ENGINEERING VARIANCE REQUEST

Project Name:	Colvin PRD
Project Number:	Pre-App 21048
Request Submittal Date:	4/15/2022

**Re: Colvin PRD – Hammerhead Variance Request
 CORE Project No. 21387**

PRELIMINARY ROAD, GRADING & UTILITY PLAN
COLVIN PRD

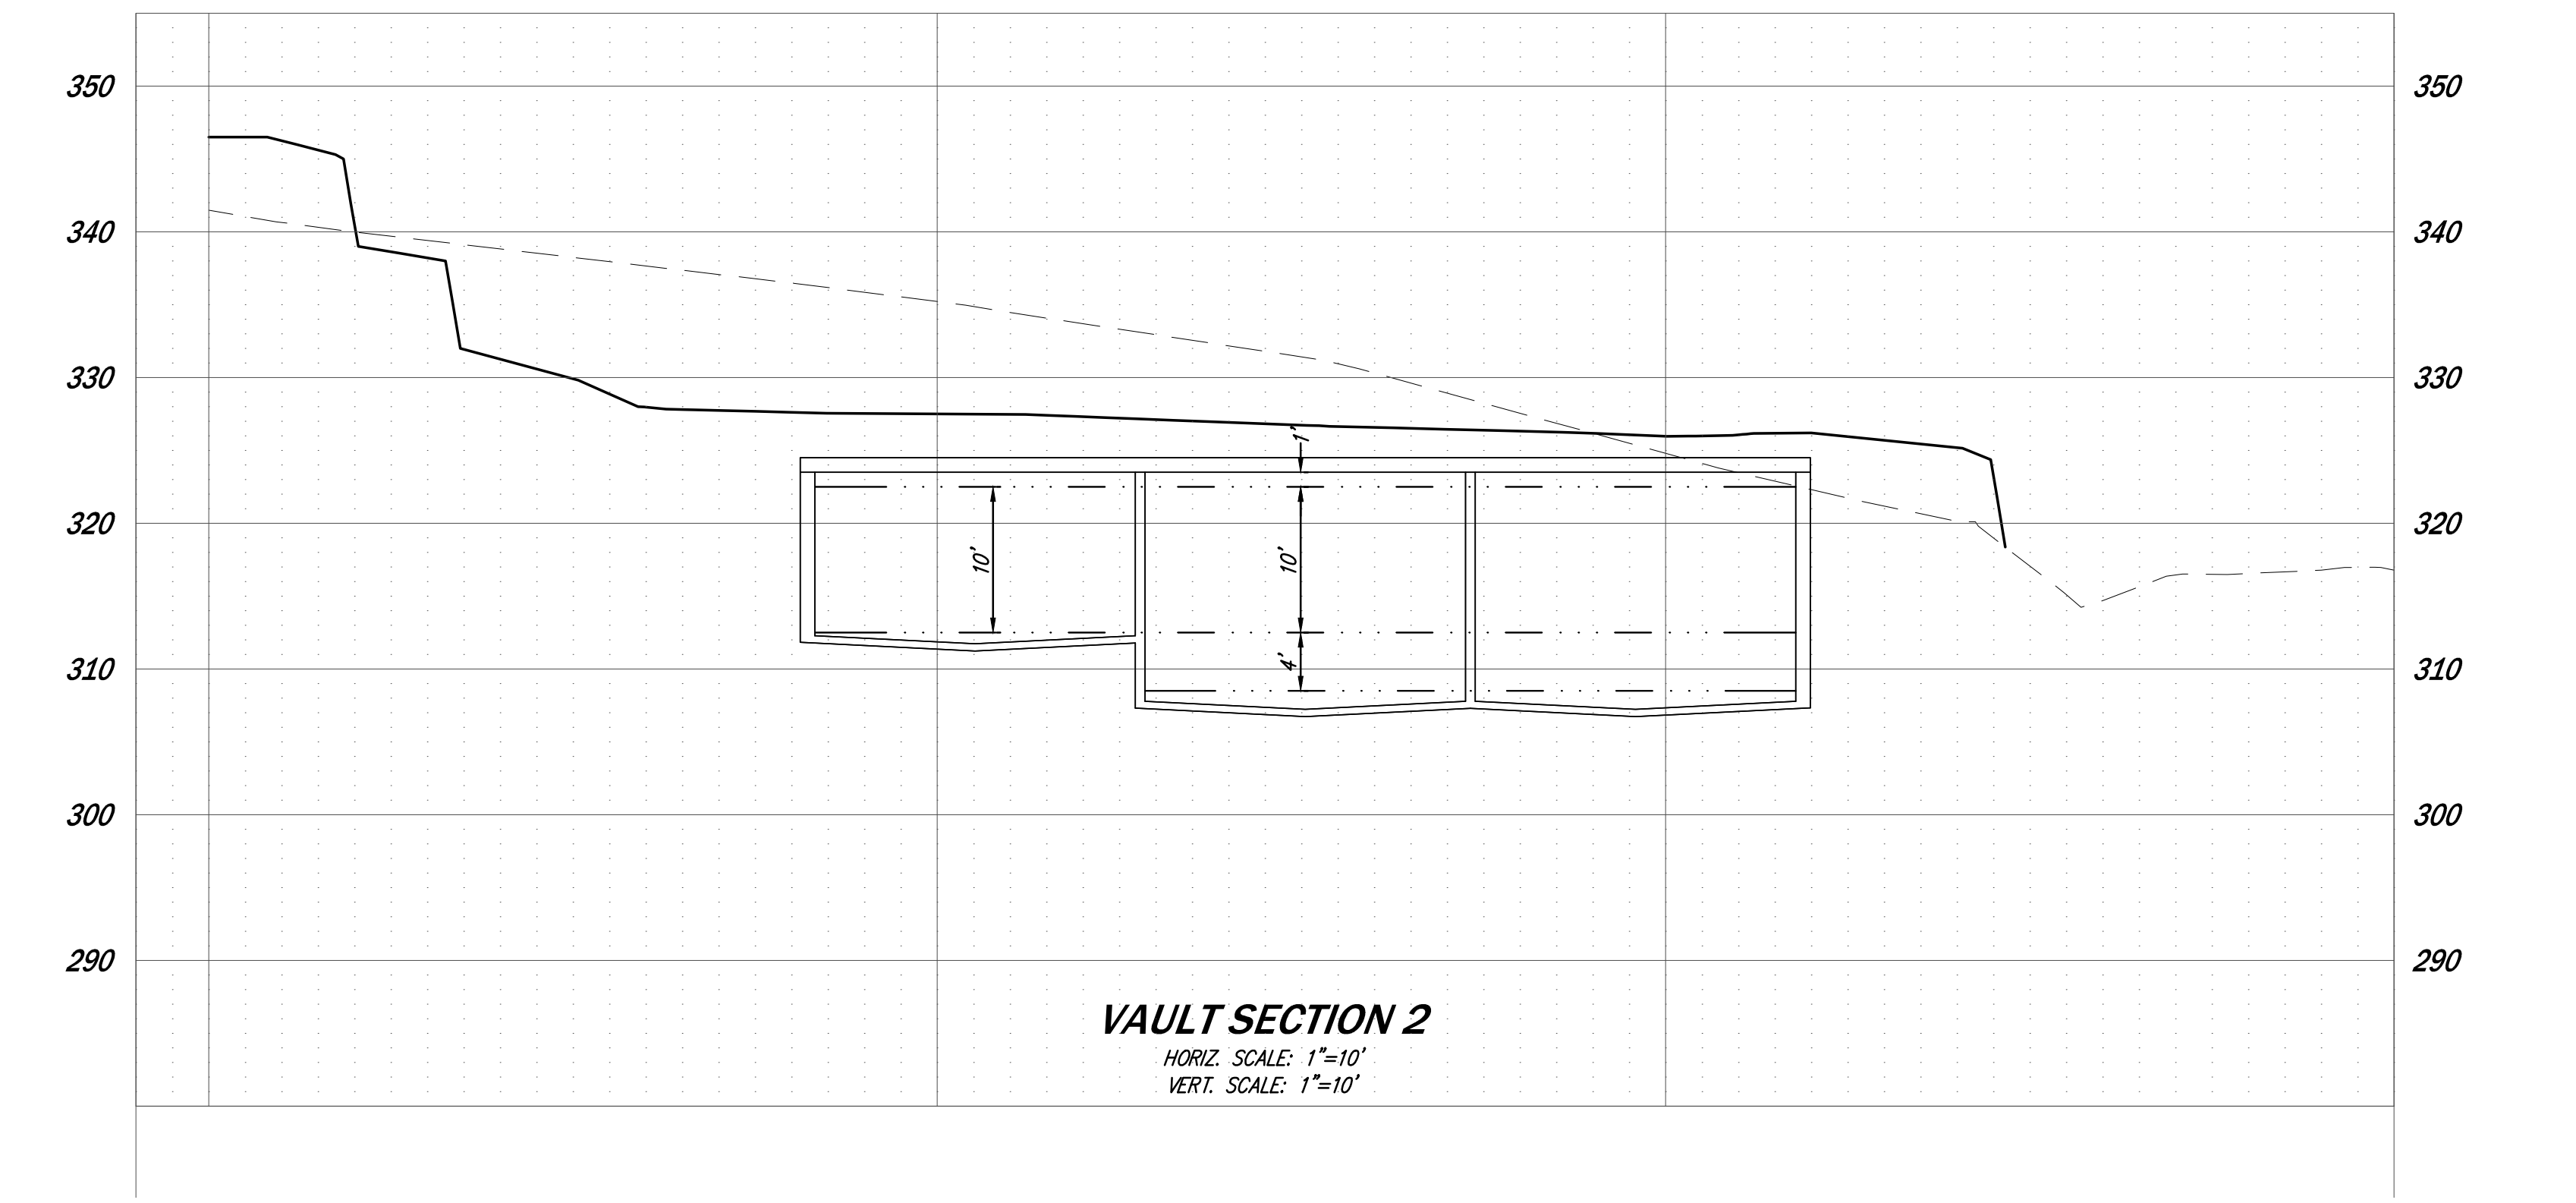
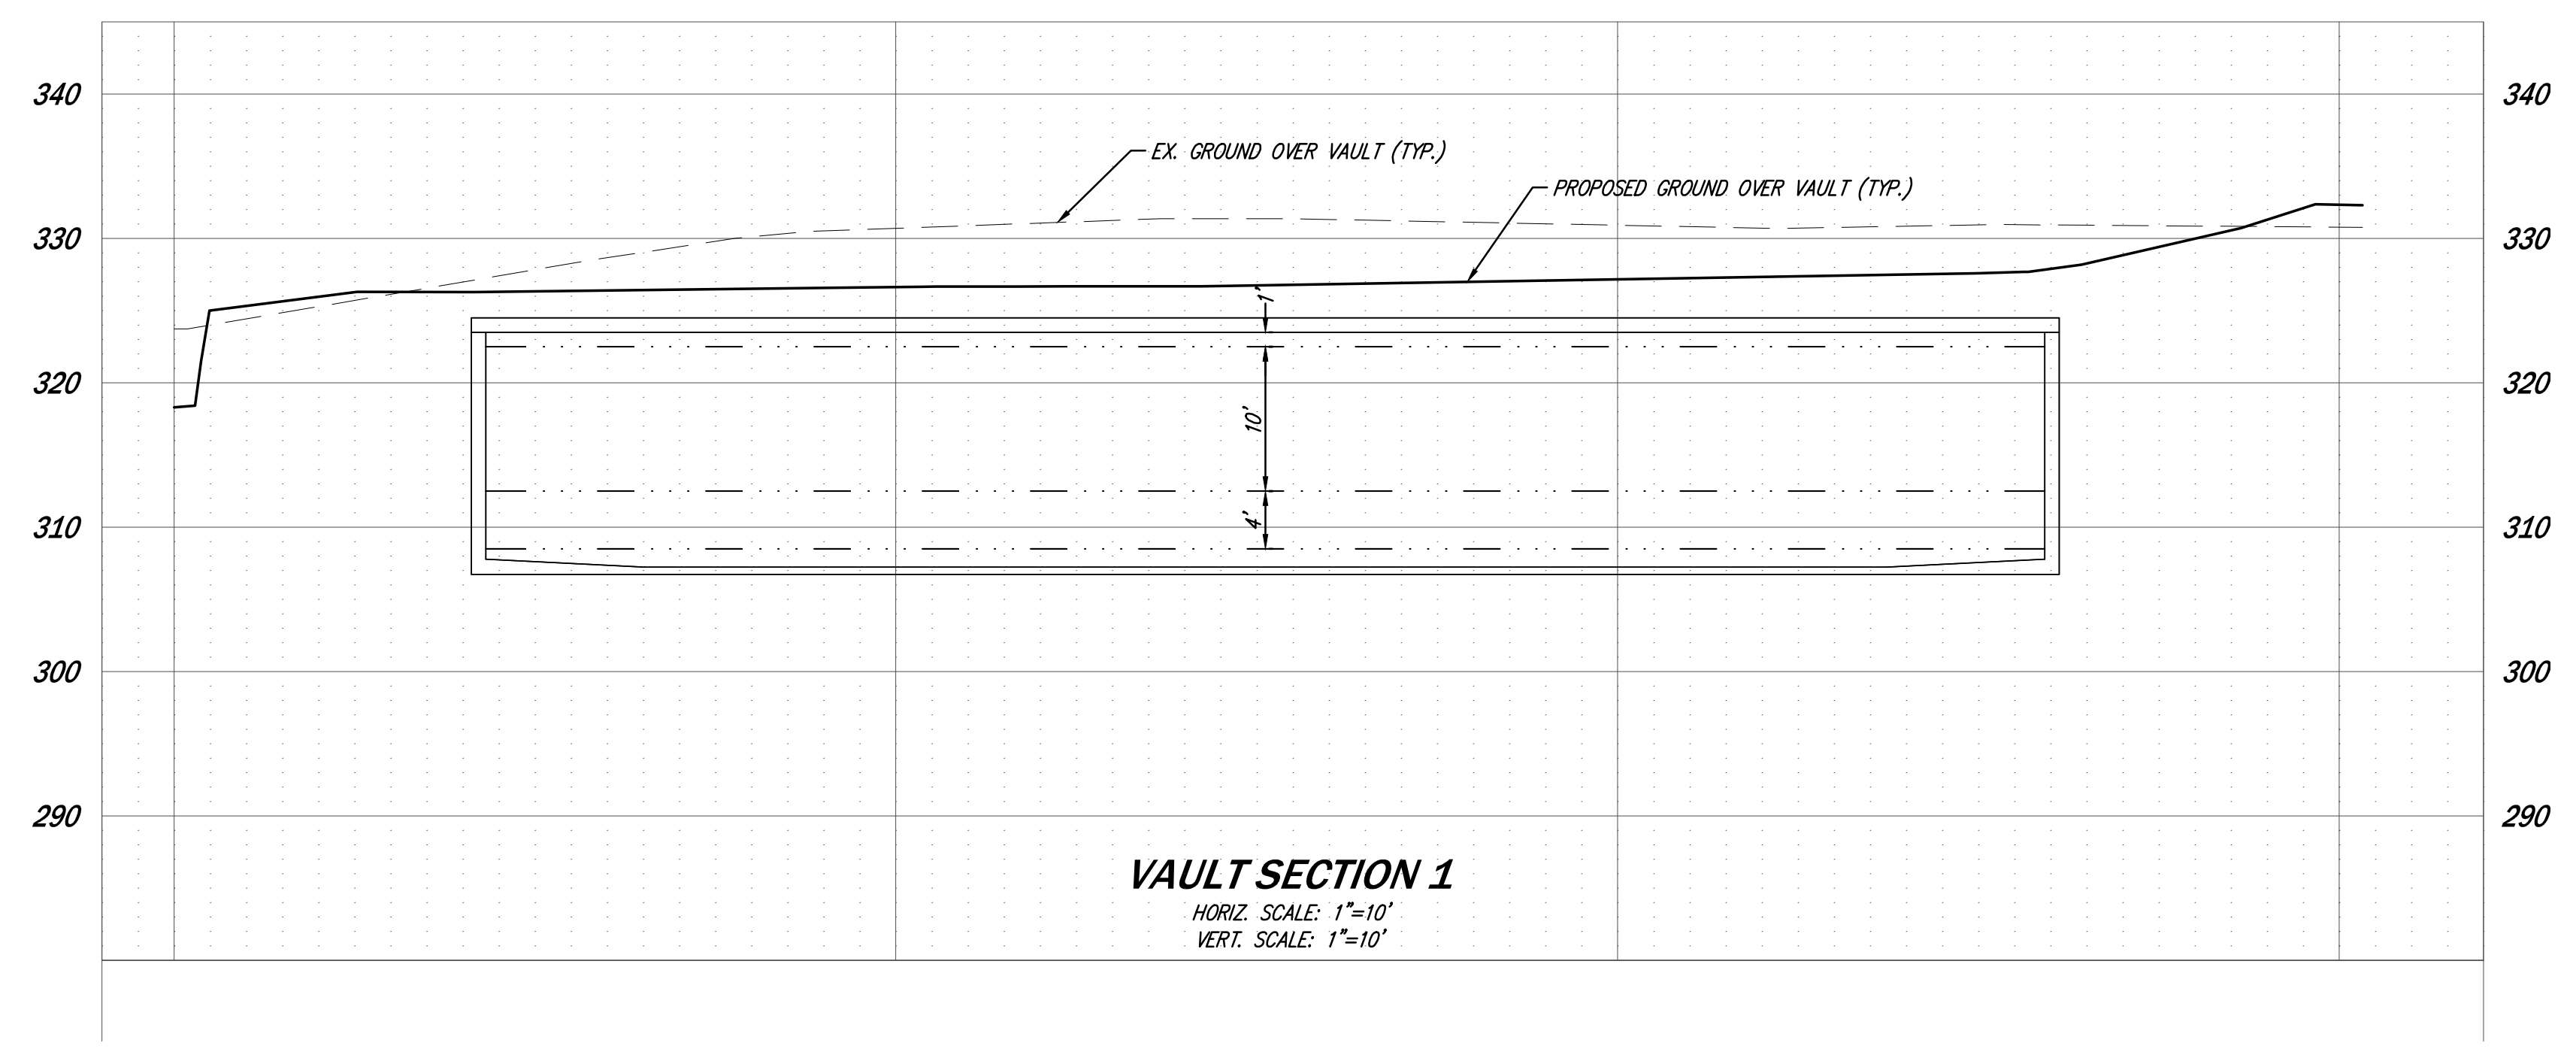
This letter is to address the justification for the applicants request to construct permanent hammerhead turnaround in lieu of a temporary cul-de-sac at the southern stub of Road C. In general, the permanent hammerhead turnaround will provide the same basic function as a temporary cul-de-sac by providing vehicles an area to safely turn around.

A temporary cul-de-sac would require approximately 2,520 square feet of additional pavement to the site. Though this pavement is temporary, once the southern stub road is connected site construction activities would commence for the removal of this pavement and development of the additional road improvements not constructed during initial site development activities. This would subject the residents of the Colvin PRD to additional construction activities and would temporarily deprive them of completed streets.

In place of the temporary cul-de-sac the applicant is proposing a permanent hammerhead turnaround. The proposed turnaround will remain even after the southern right-of-way stub is connected to. Thereby providing the Fire Department a permanent alternative turnaround location.

Instead of providing a temporary turnaround, a permanent turnaround that meets Marysville EDDS dimensional standards is being proposed.

FINDINGS/DECISION (City Staff Use Only)	
Reviewing Staff Member:	Ken McIntyre, PE - Asst. City Engineer
\$250 Application Fee Submitted:	<input type="checkbox"/> Yes <input checked="" type="checkbox"/> Deferred
Decision:	<input checked="" type="checkbox"/> Approve <input type="checkbox"/> Approve with Conditions <input type="checkbox"/> Disapprove
<u>Findings/Decision/Conditions:</u> The City is in agreement with the justification provided. There has also been recent development interest in the property immediately south, so it's likely that the road will be extended from this location in the not-too-distant future. The local Fire District has recently accepted the use of hammerhead turn-arounds in similar circumstances.
